# D49 TRANSPORTATION CENTER

**ARCHITECTURAL SITE PLAN - PHASING PLANS**

# v5\_Site Plan-redline.pdf Markup Summary

**GRAVEL ROAD PLAN**  
SCALE: 1"=20'

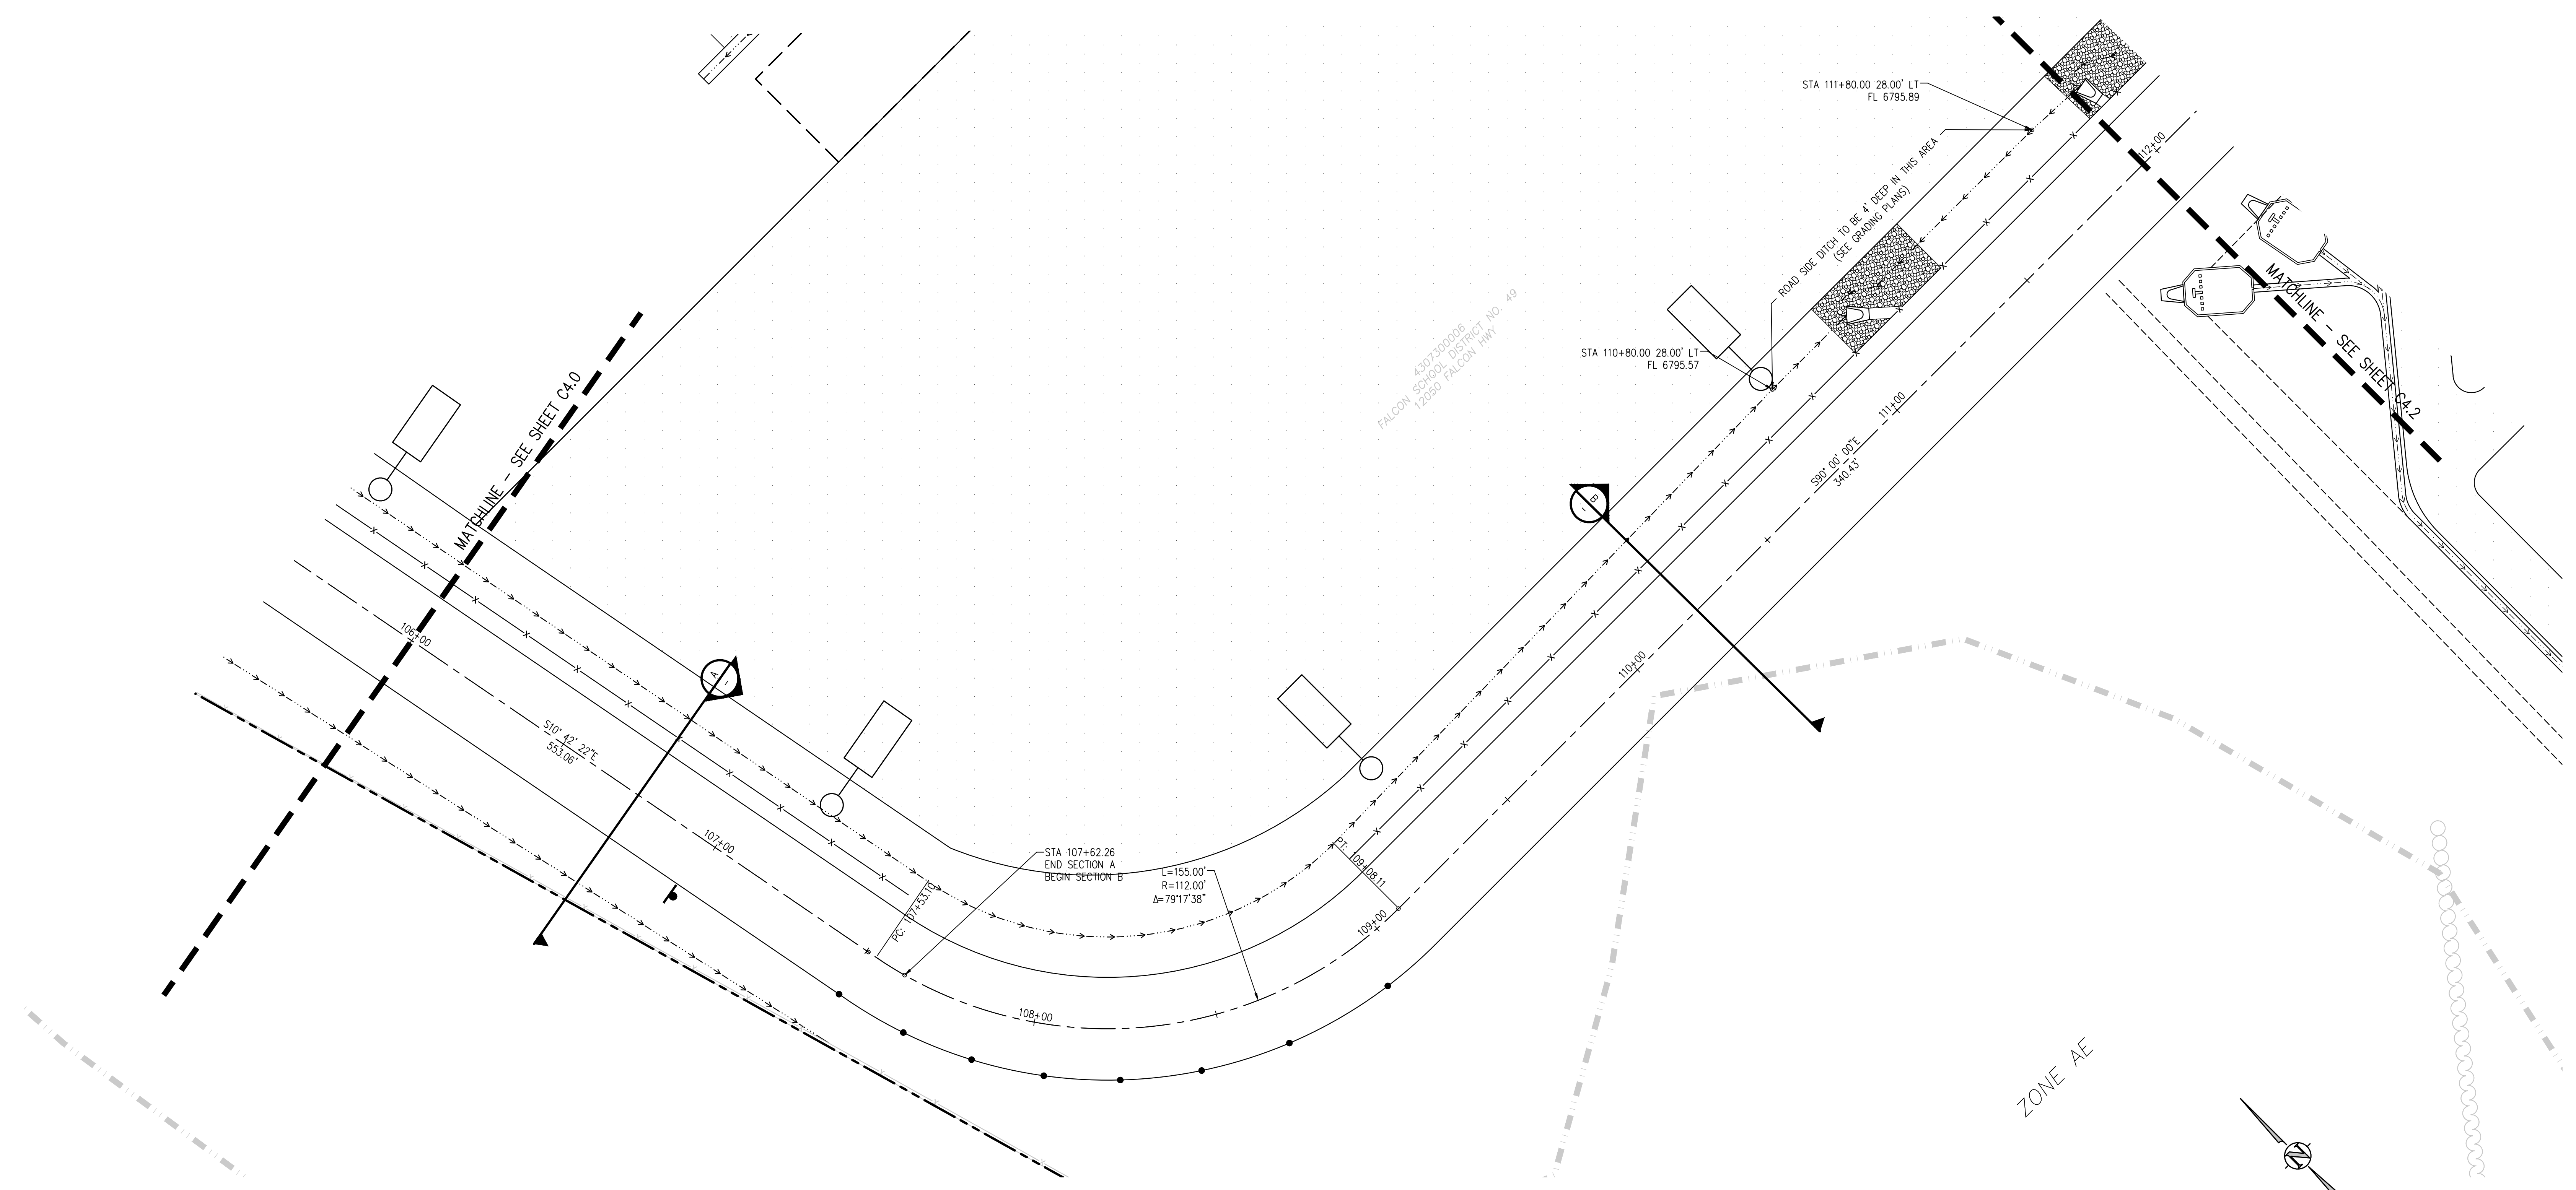
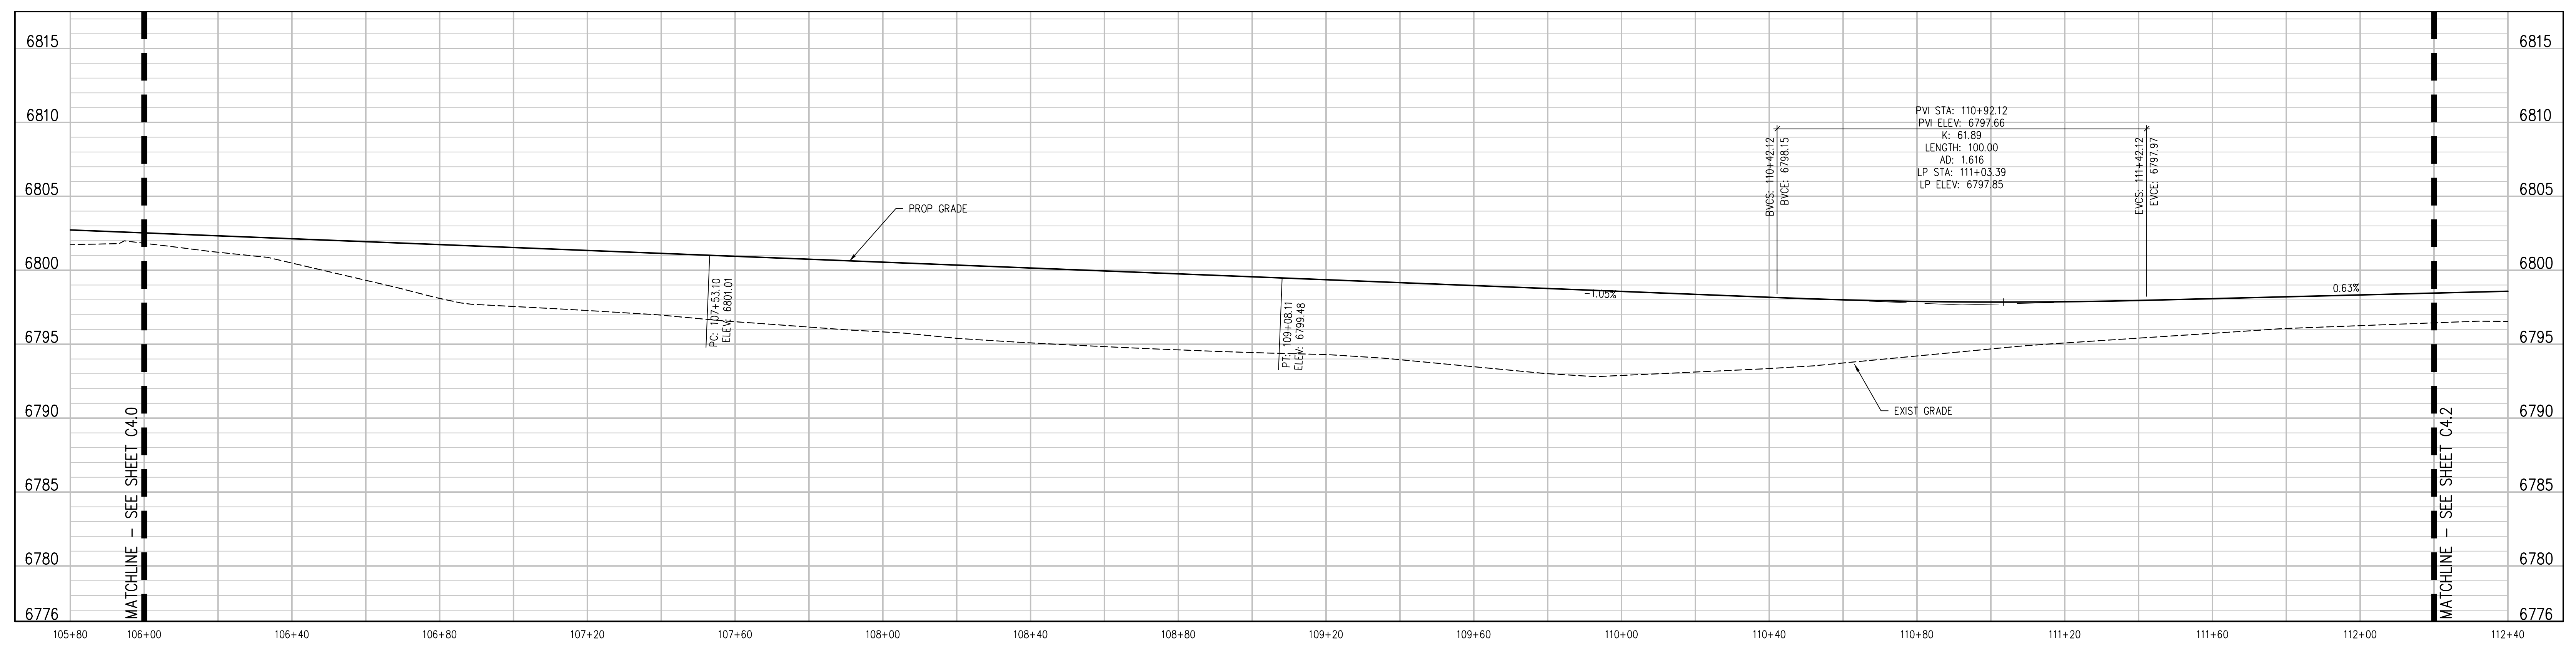
Note: pending resubmittal of traffic study might change the condition of road. Coordinate with traffic engineer to determine whether the road will have to be paved.
